**OXFORDSHIRE COUNTY COUNCIL'S RESPONSE TO CONSULTATION ON THE
FOLLOWING DEVELOPMENT PROPOSAL**

Application no: 15/00344/REM

Proposal: 108 dwellings, associated parking and access arrangements, drainage, landscaping and materials

Location: Parcel E Phase 4, Longford Park Road, Bodicote

Copyright reserved

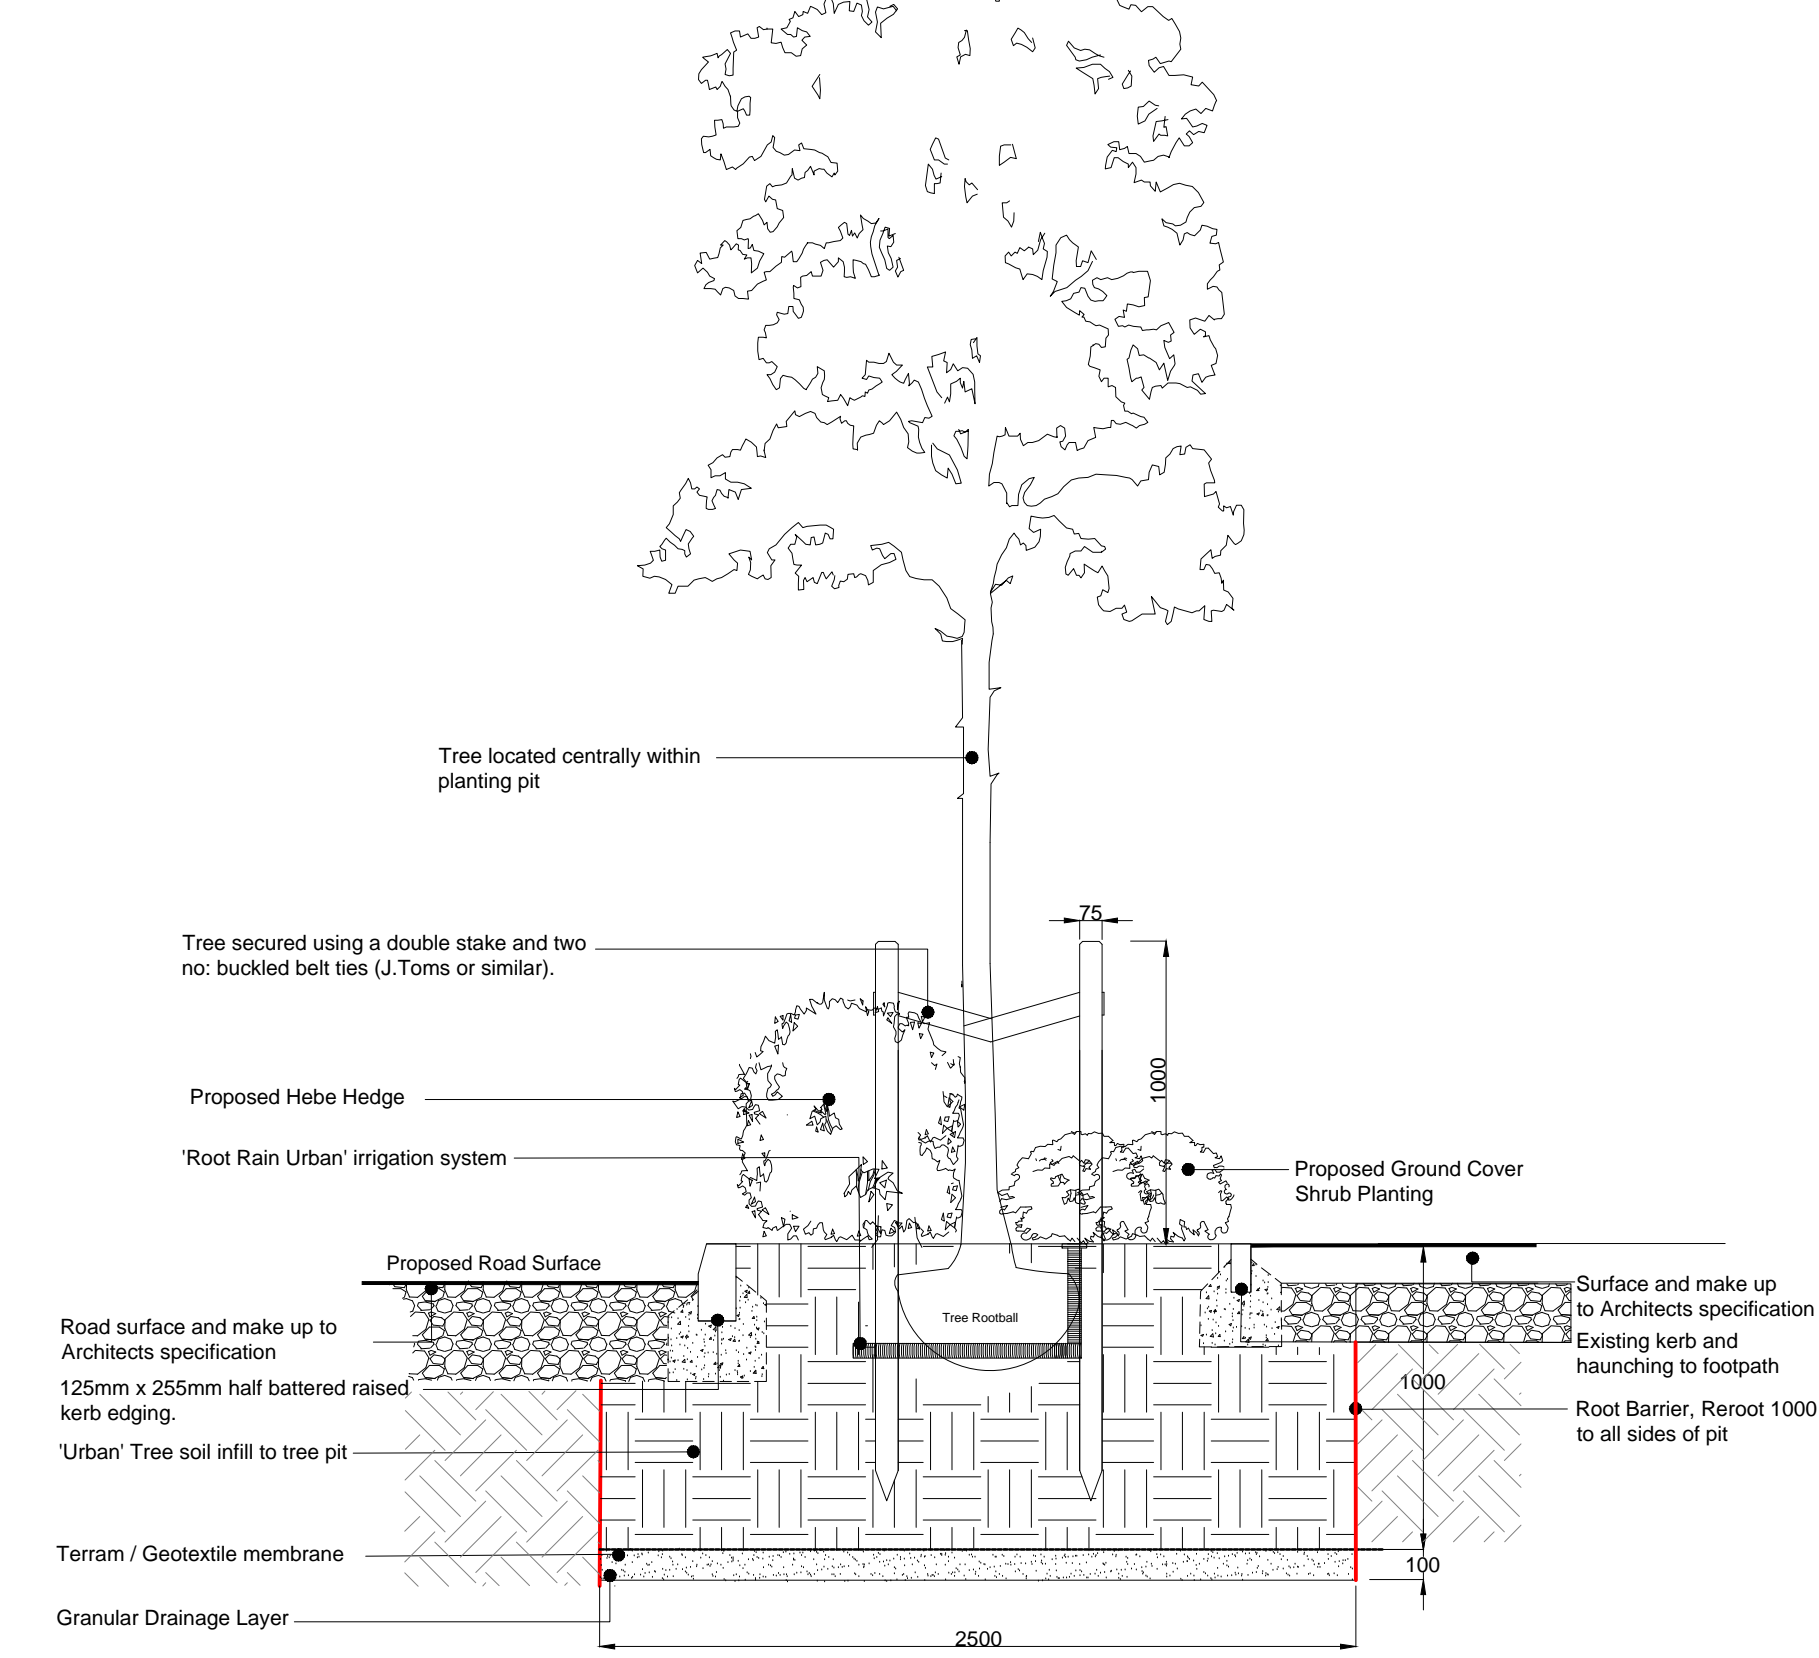
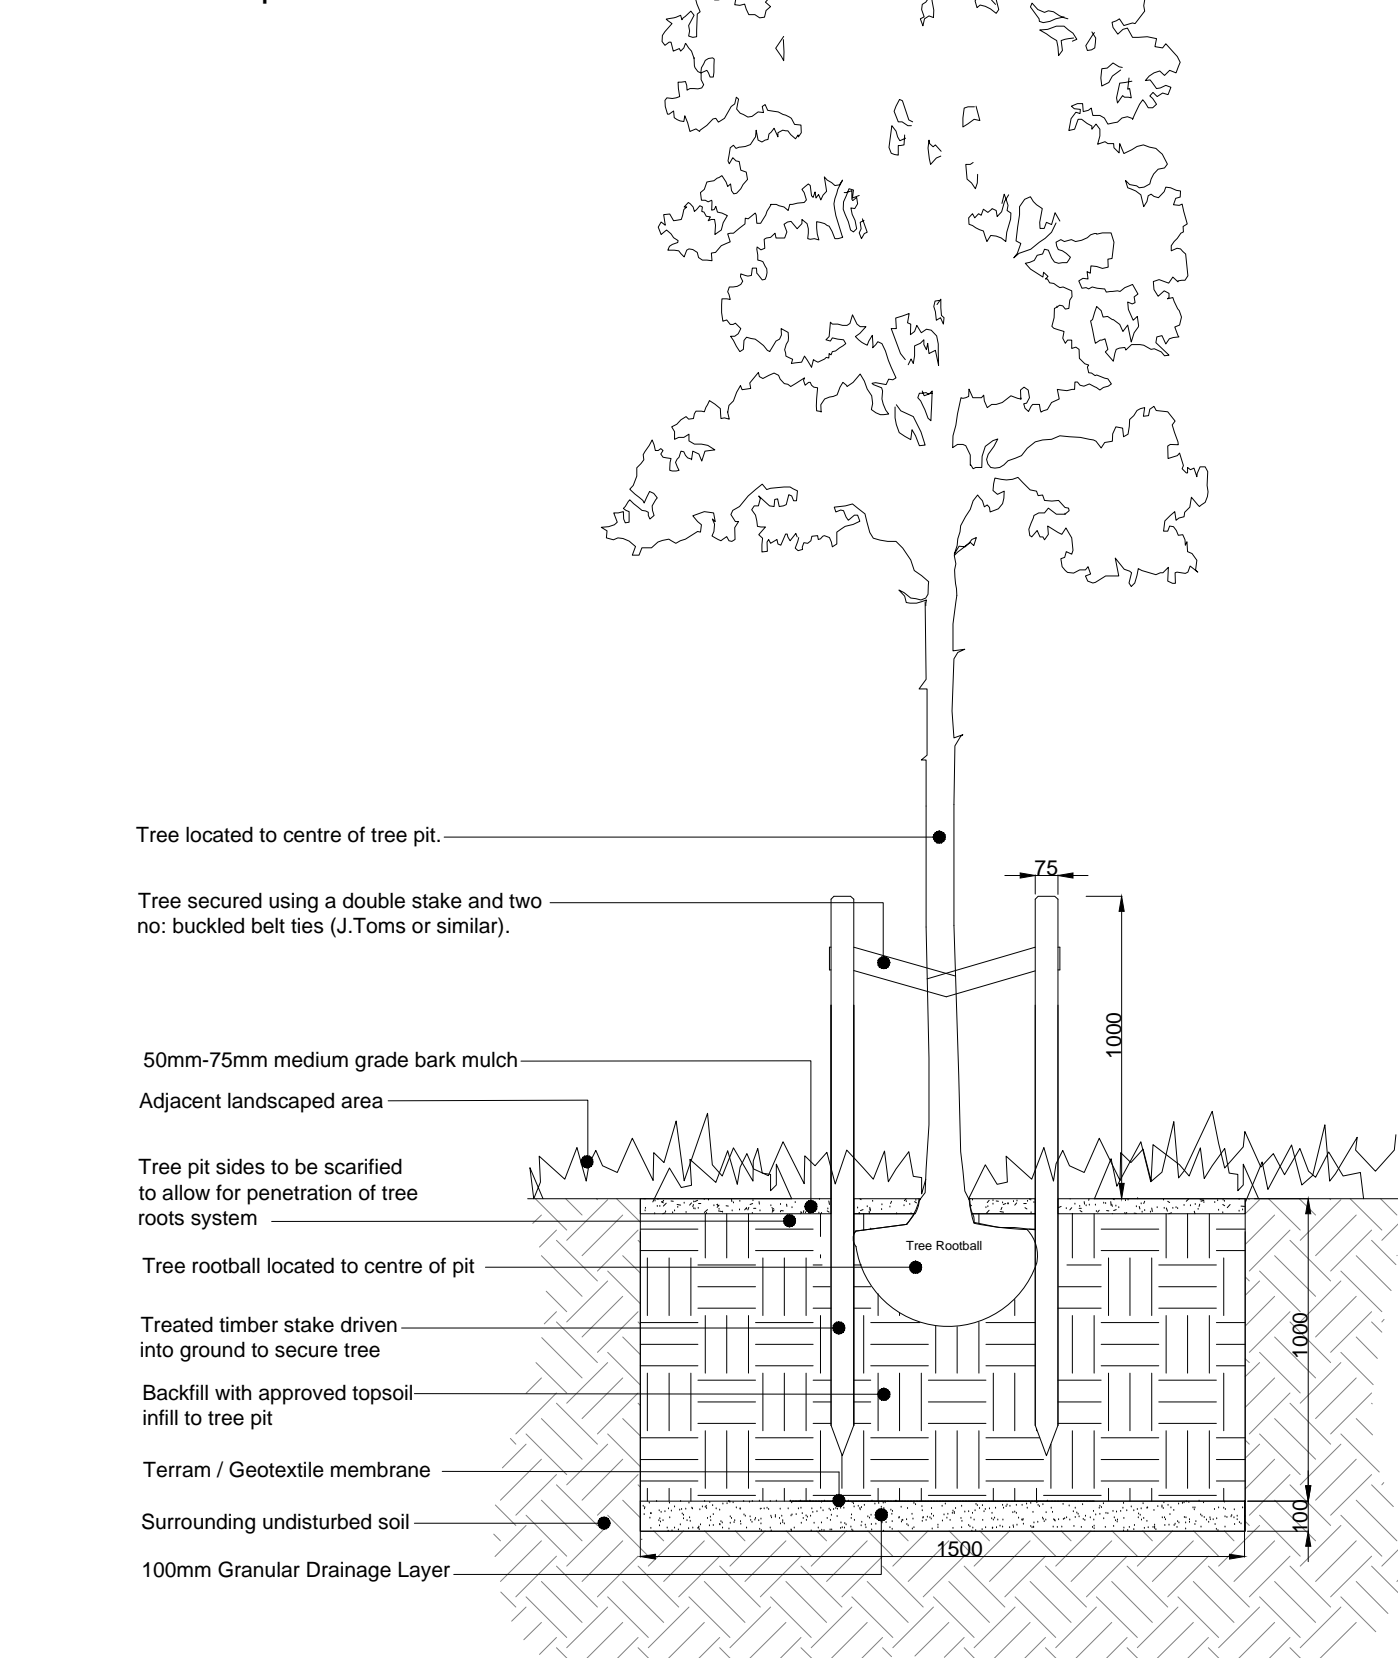
It is noted there are trees indicated on the drawing within the proposed highway on this basis it will be necessary for the applicant/developer to provide a commuted sum with respect to the future maintenance liability at a cost of £1200 per tree.
